20 December 2019

Our Ref: R/2018/3/B  
File No: 2019/635560

**Response to Submissions – Student Accommodation, 13-23 Gibbons Street, Redfern (SSD 9194)**

1 TOP EAST SIGNAGE
1:50

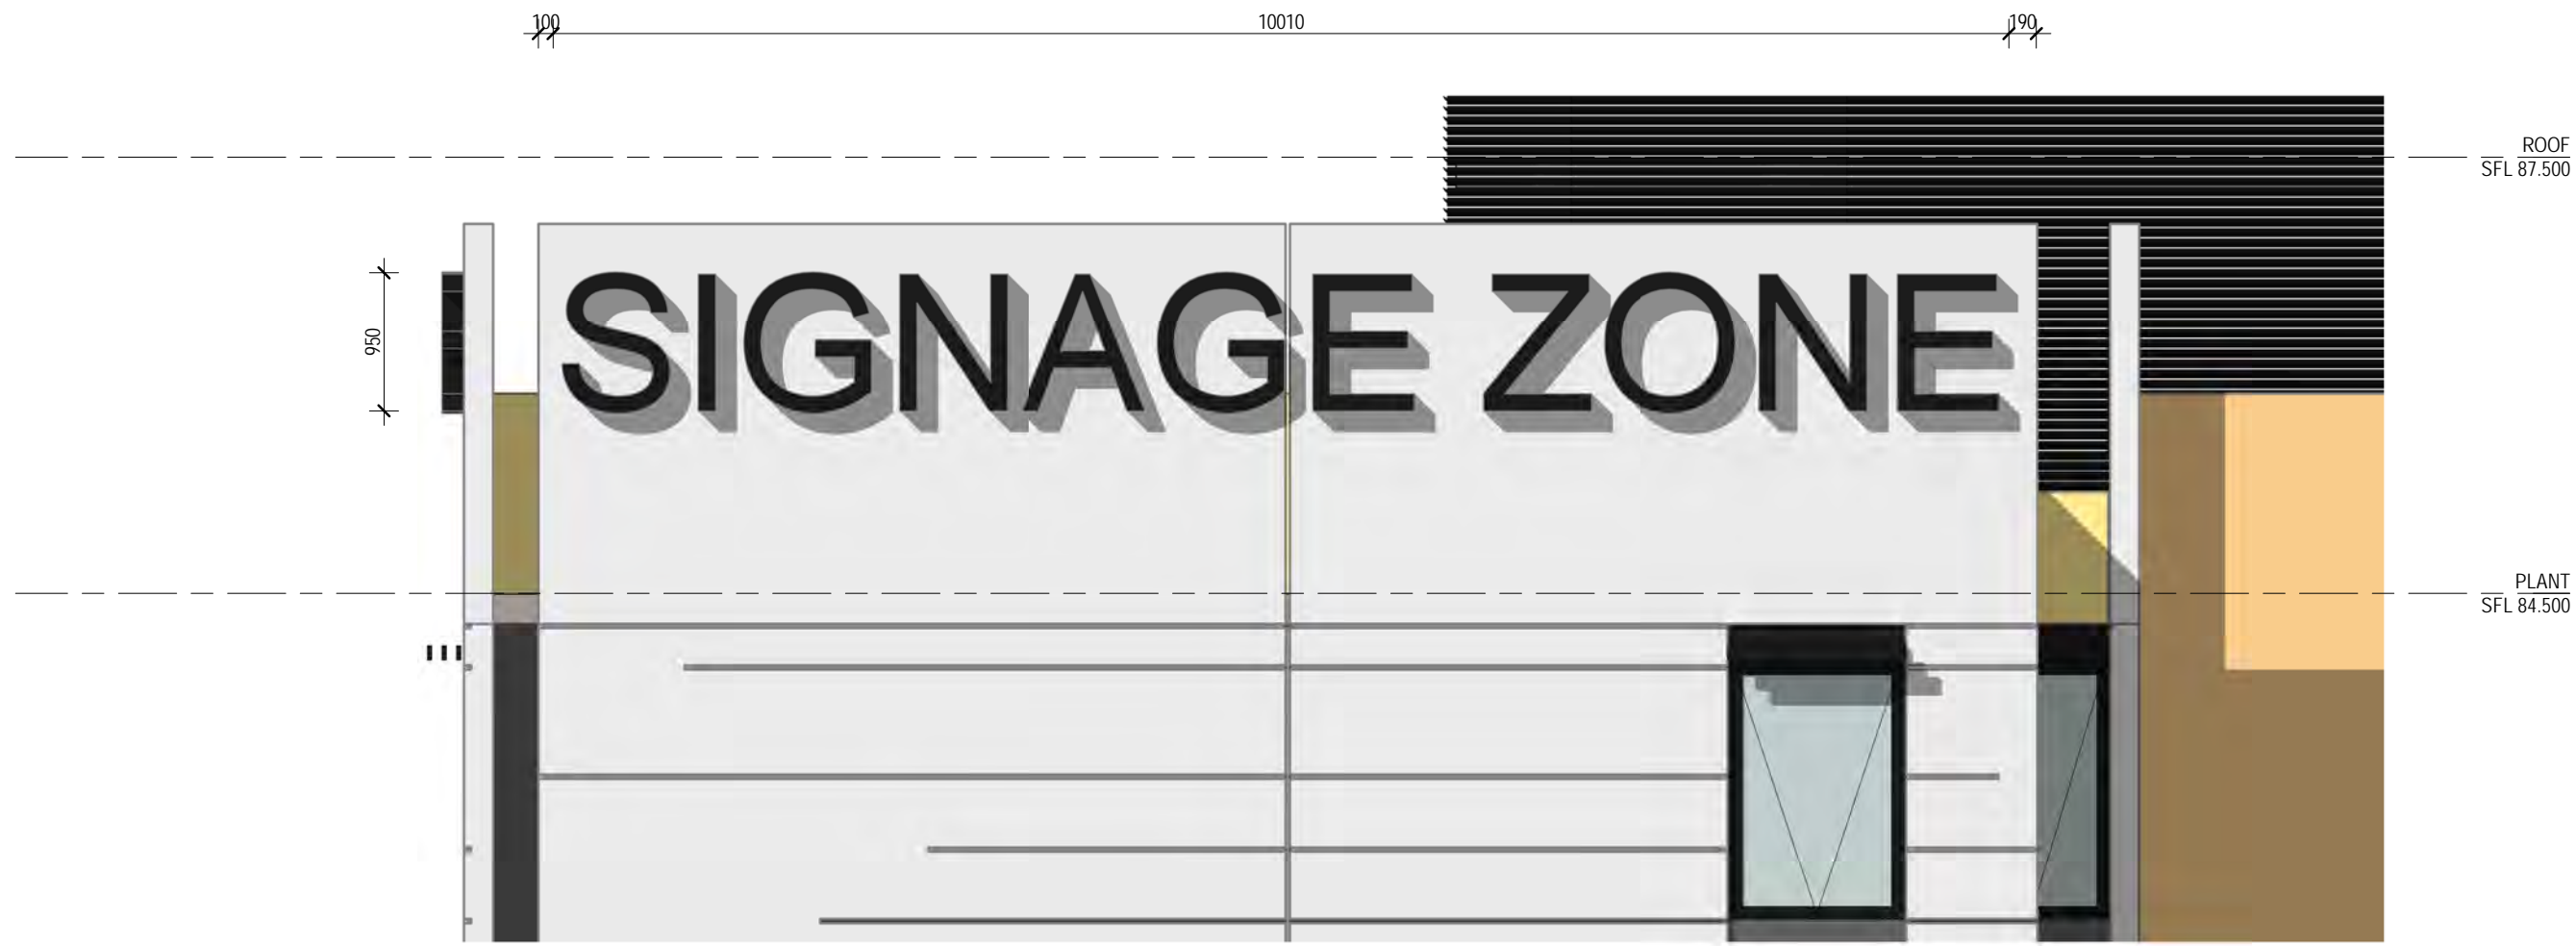
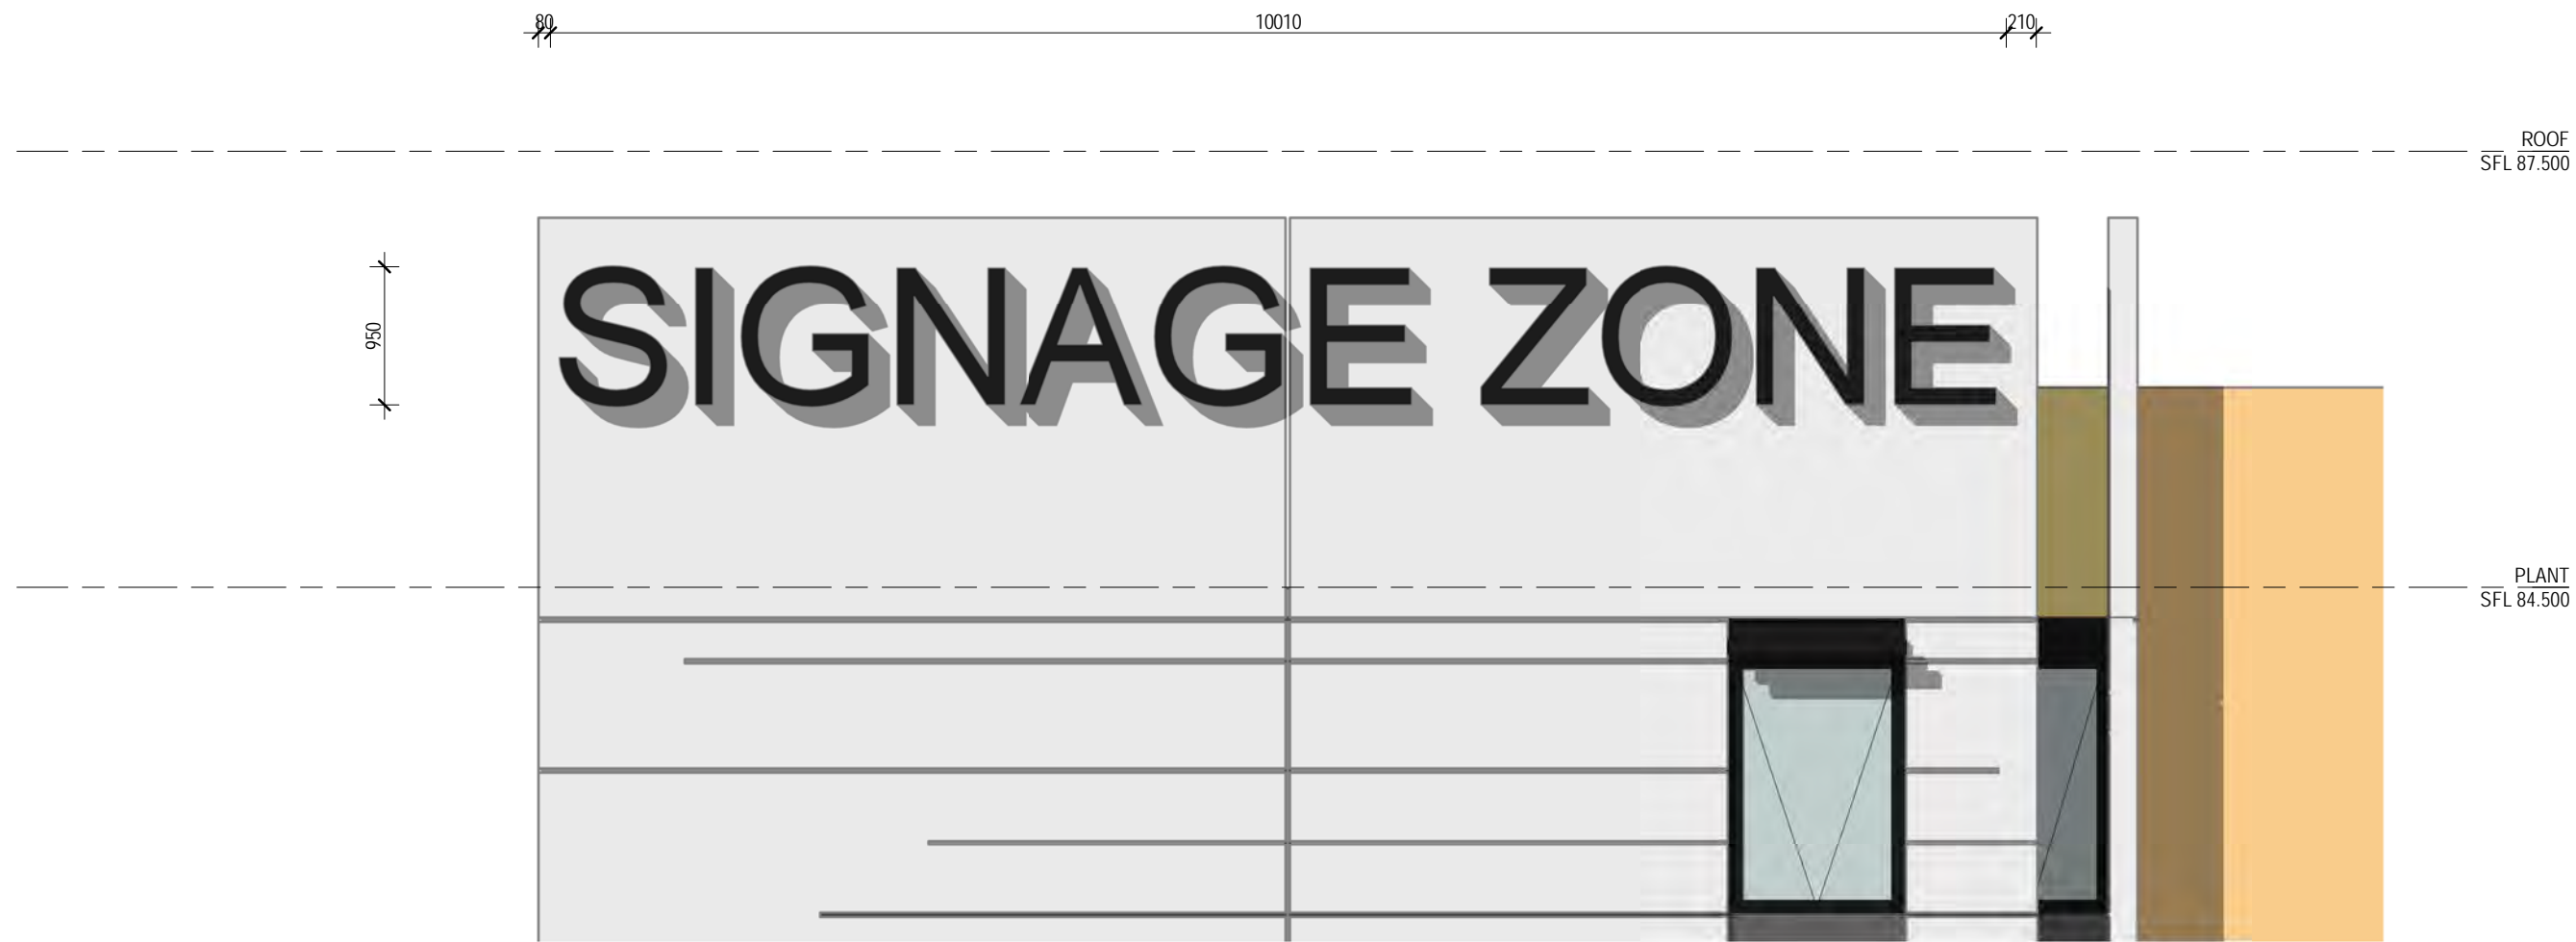
The proposed top of building signage creates bulk and visual clutter. It is out of character with the adjacent low scale area to the south, nor are there any projecting wall signs at the top of the building within the Redfern-Waterloo Authority land to the north. A smaller projecting wall sign is proposed above the awning on Gibbons Street. The sign is not supported and would be more in keeping with signage in this area as a wall sign.

2 East Elevation Detail

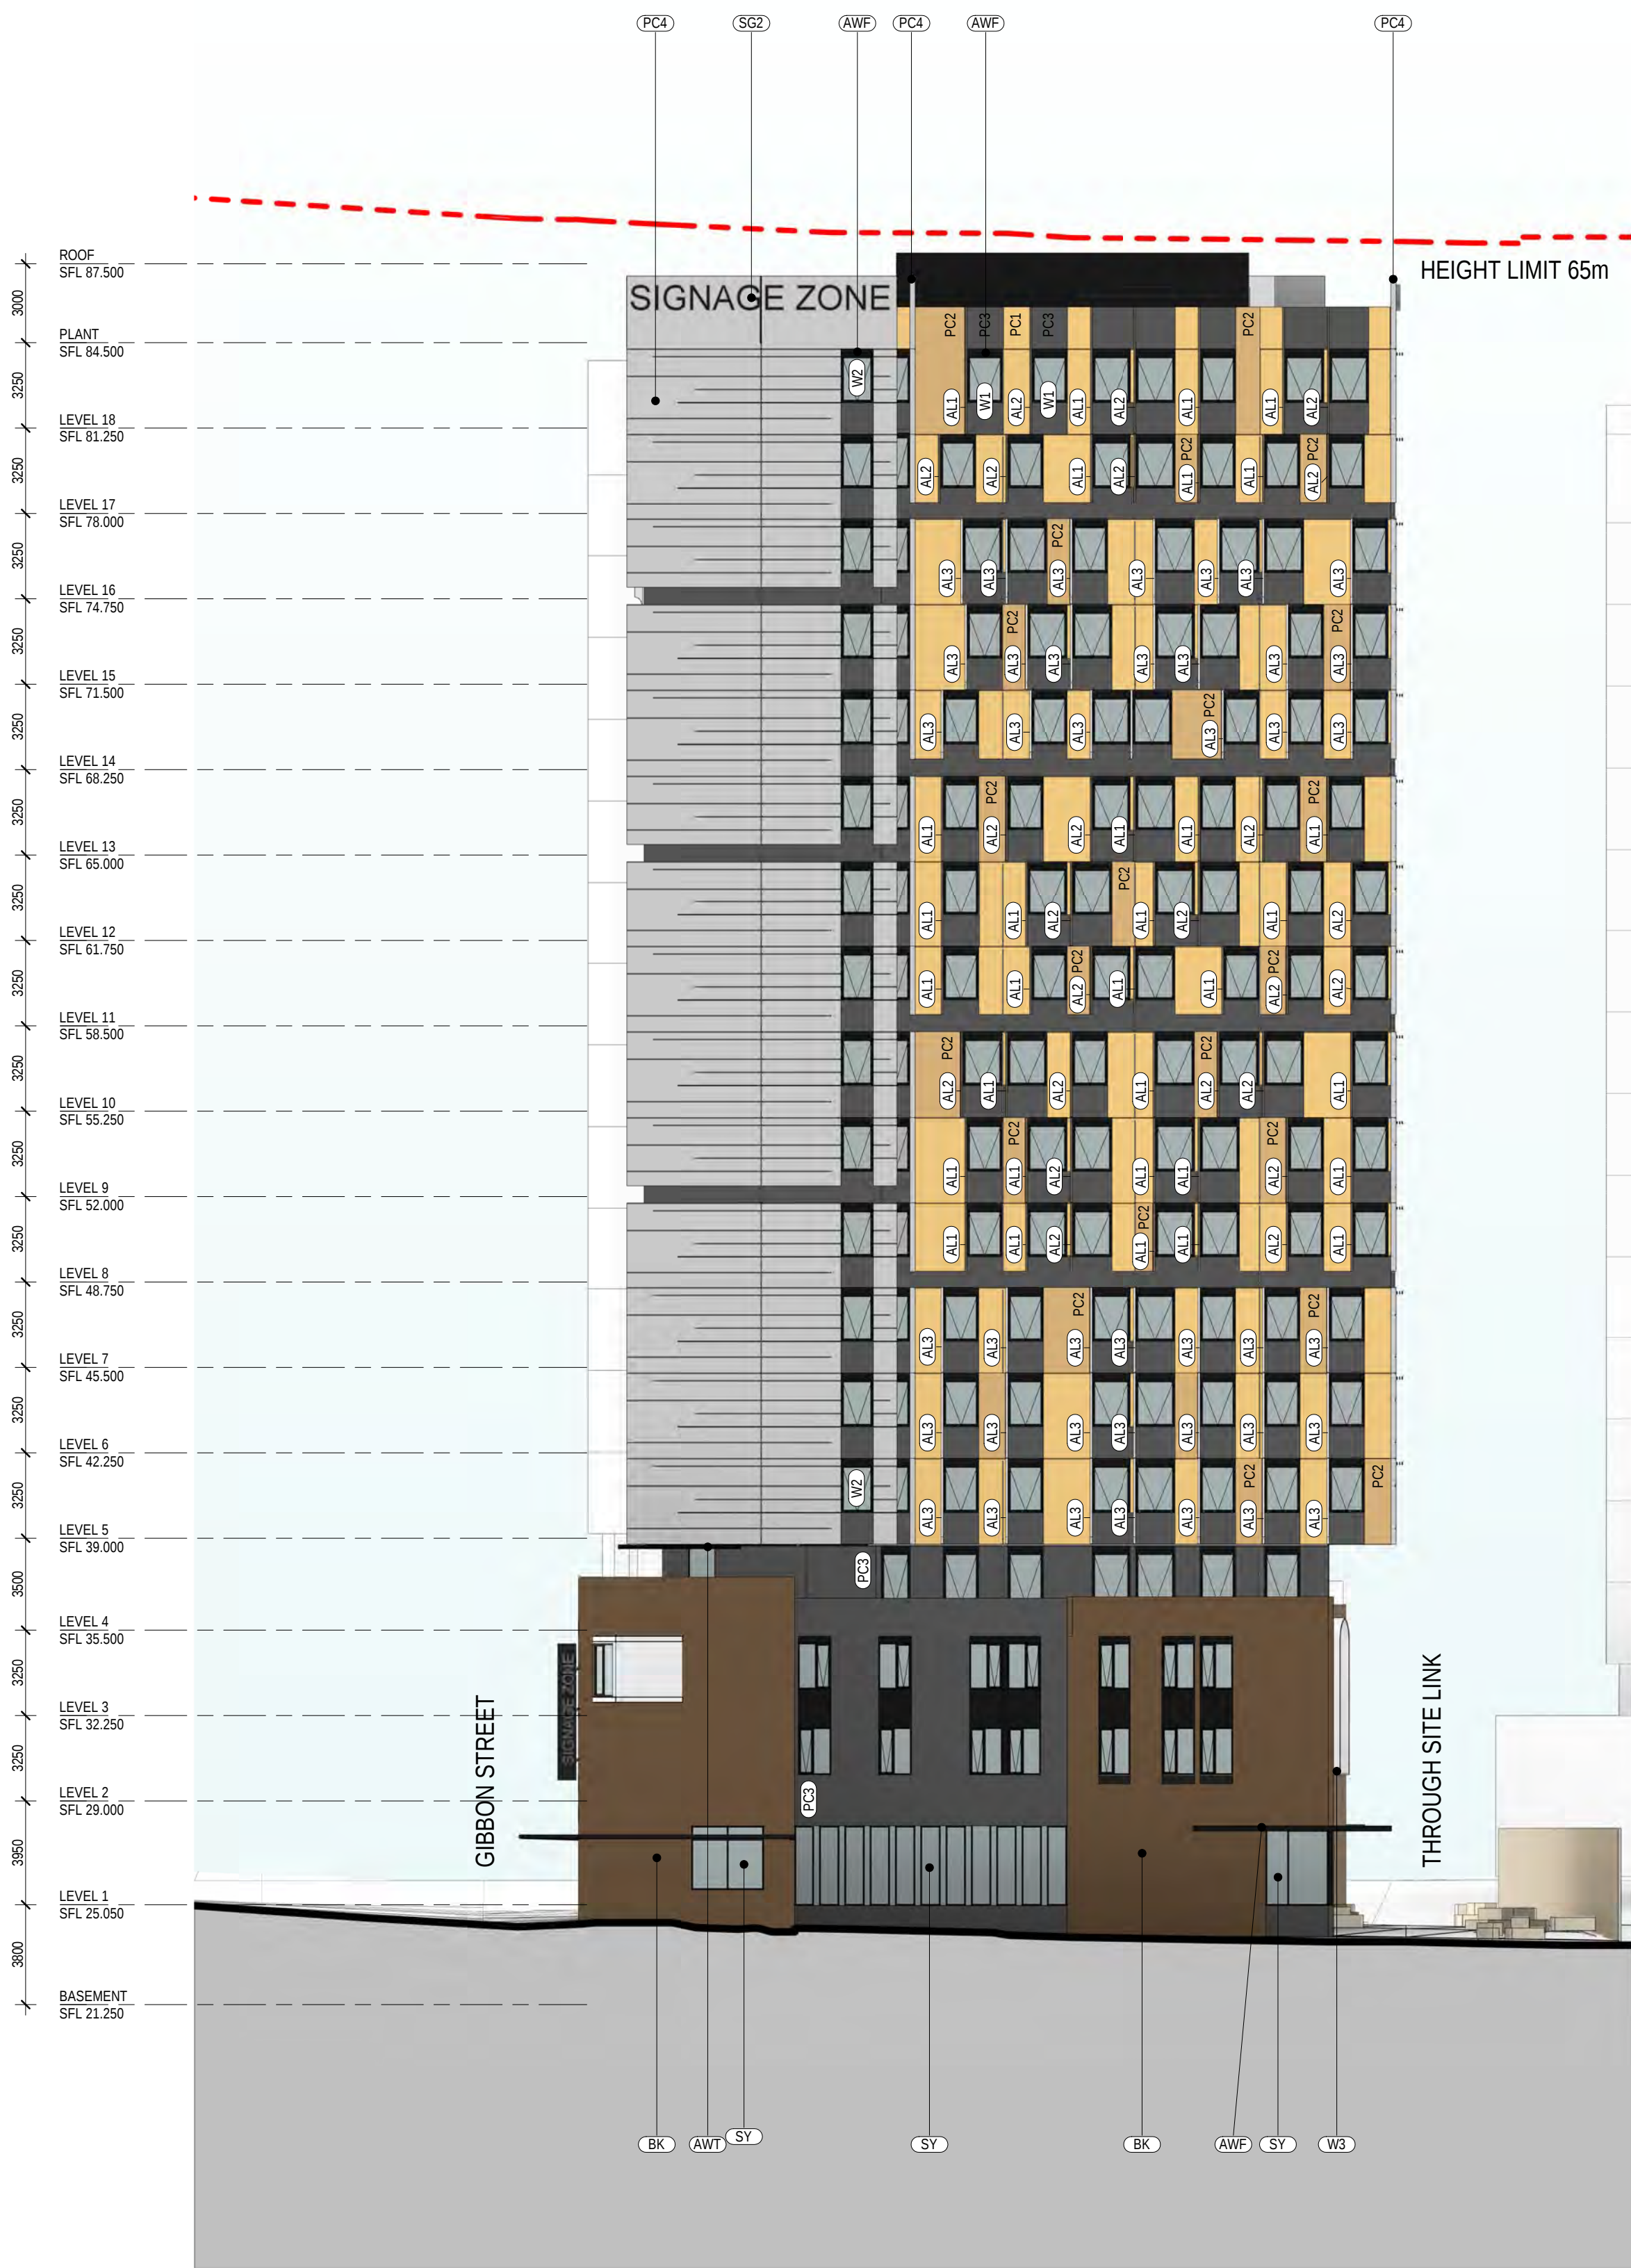
The City provides an extract of the east elevation (Gibbons Street) superimposed with the approved elevation of 11 Gibbons Street in **Attachment A**. To summarise, the building expression of the tower can be improved through the simplification of the horizontal elements into 3 evenly distributed parts.

It is recommended that the shadow line between the tower and podium be maintained to break up the mass of the overall building. It is also recommended that the proposed podium be amended to match the podium height of 11 Gibbons Street and 'step up' to the corner of Gibbons Street and 'step down' along Margaret Street to correlate with the 2 to 3 storey scale to the south of the site. To this effect, the building expressions would be greatly improved and would positively respond to its context.
